Our ref: MP 10\_0107

### **Major Project 10\_0107 – Residential Development Buildings 1, 2 & 3, 61 Mobbs Lane, Epping**

### ADDITIONAL INFORMATION REQUIRED

01 GROUND FLOOR PLAN

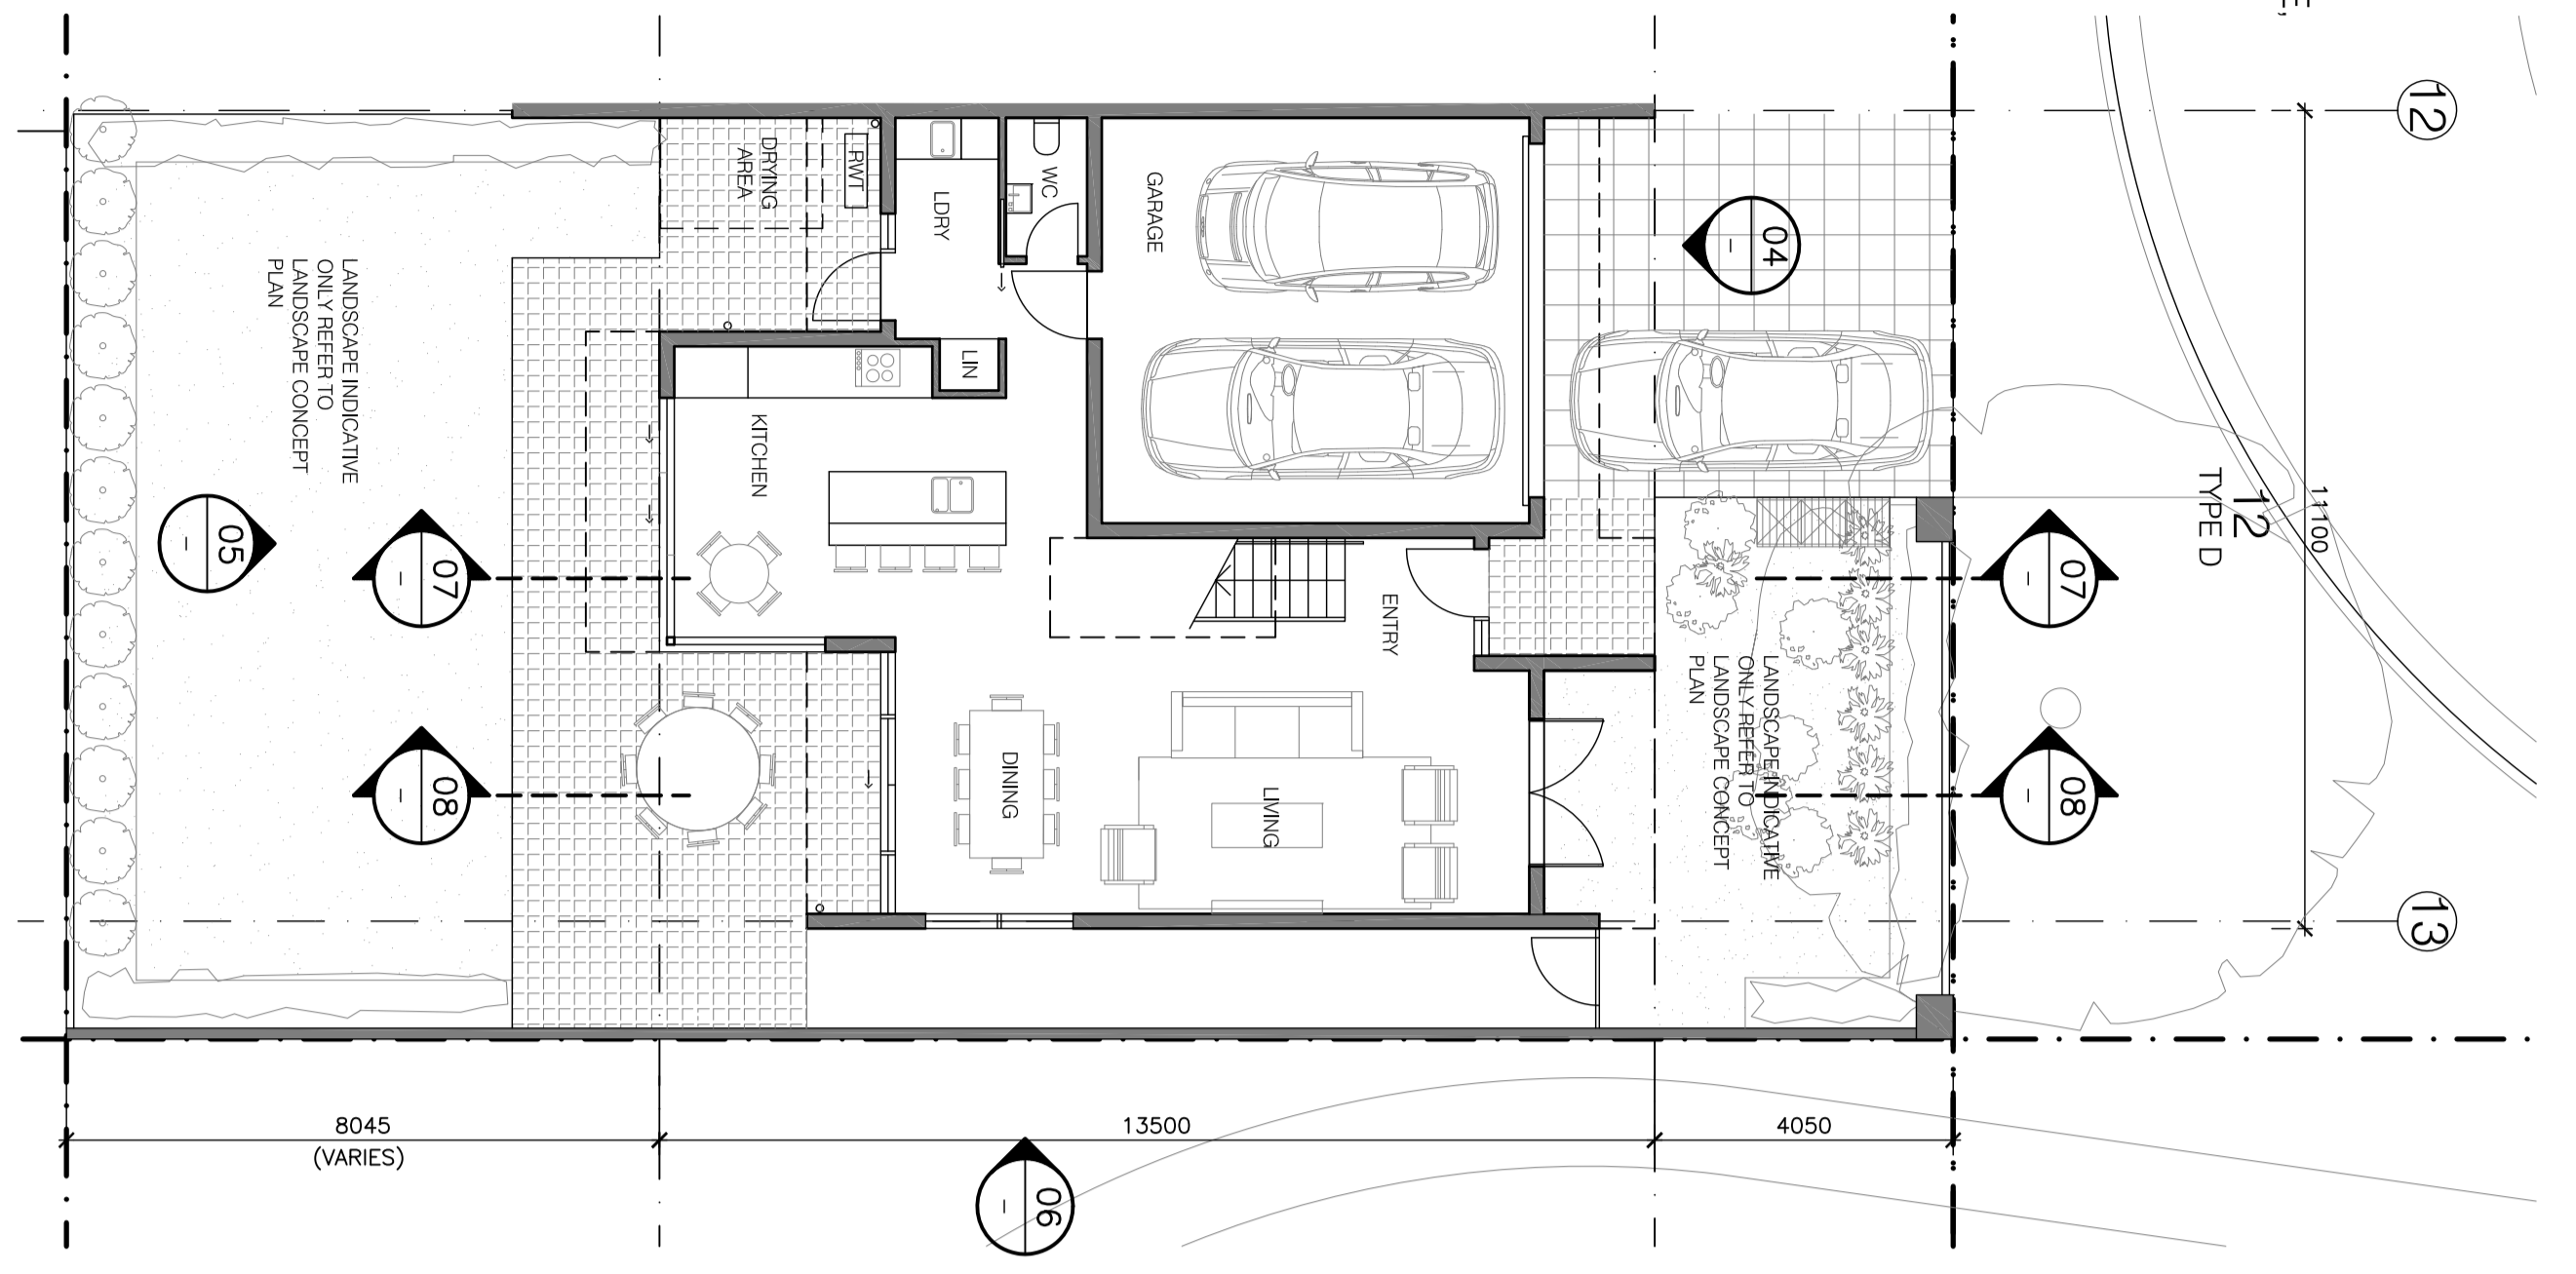
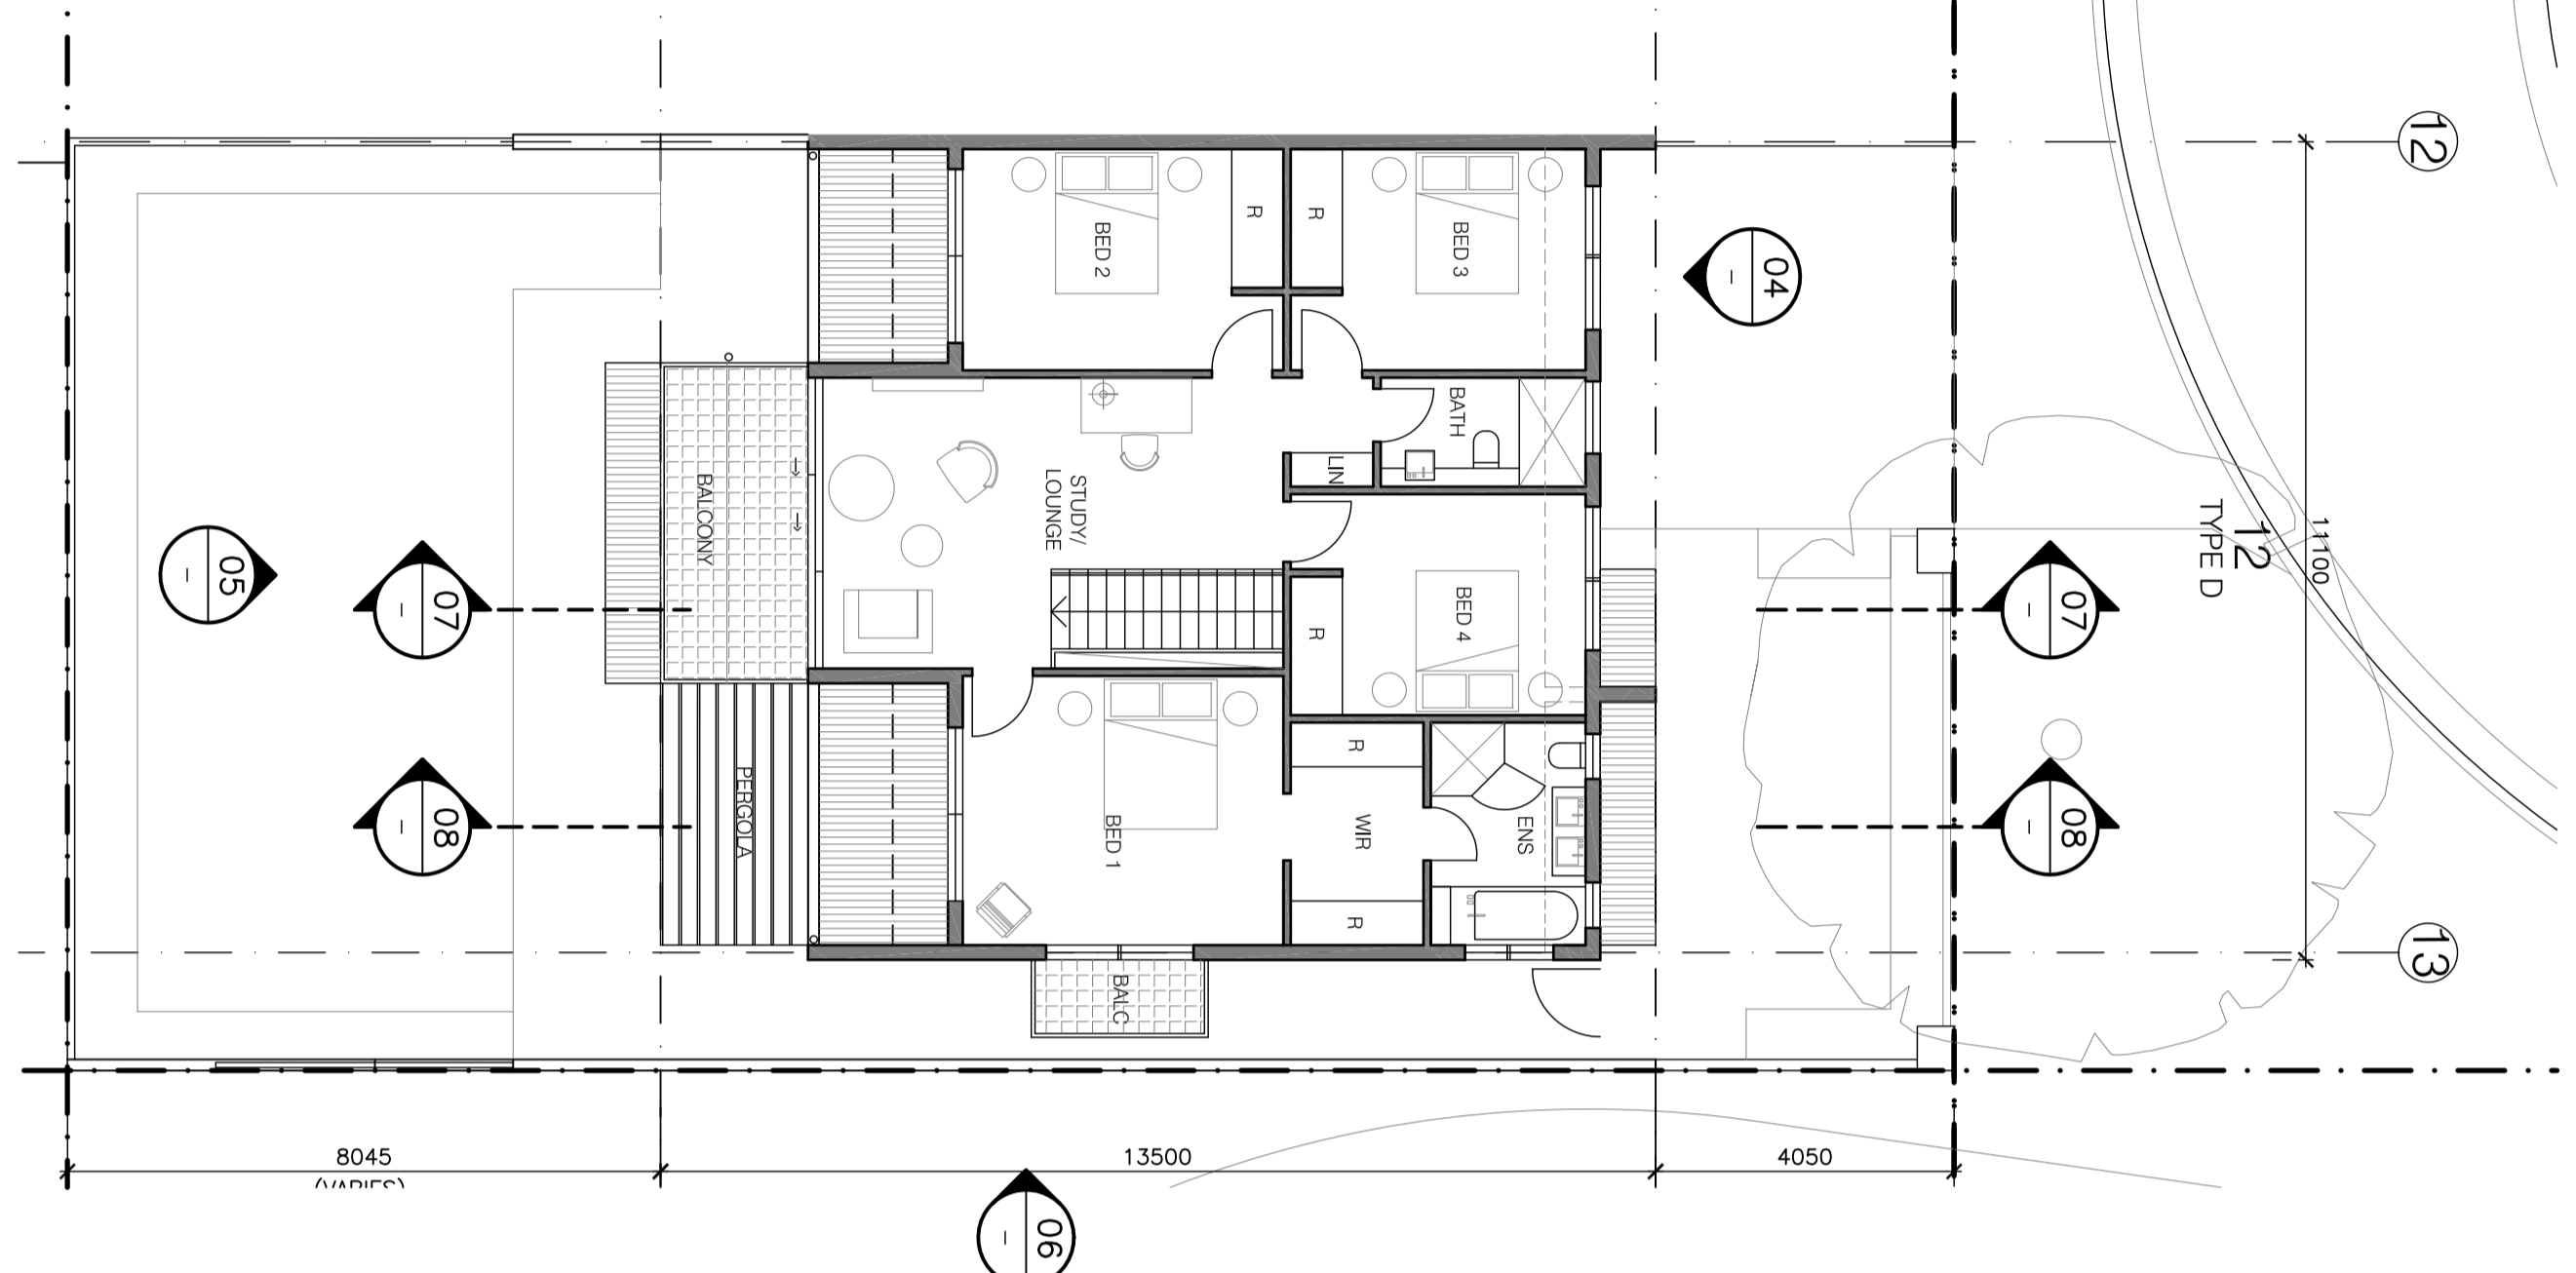
#### **1. Usability of Private Open Space to Building 3**

Consideration should be given to increasing the usability of the rear private open space to those dwellings within Building 3 which experience significant changes in levels.

#### **3. Adaptability**

Confirmation is requested as to the potential compliance of the dwellings within Building 3 with AS 4299 Adaptable Housing.
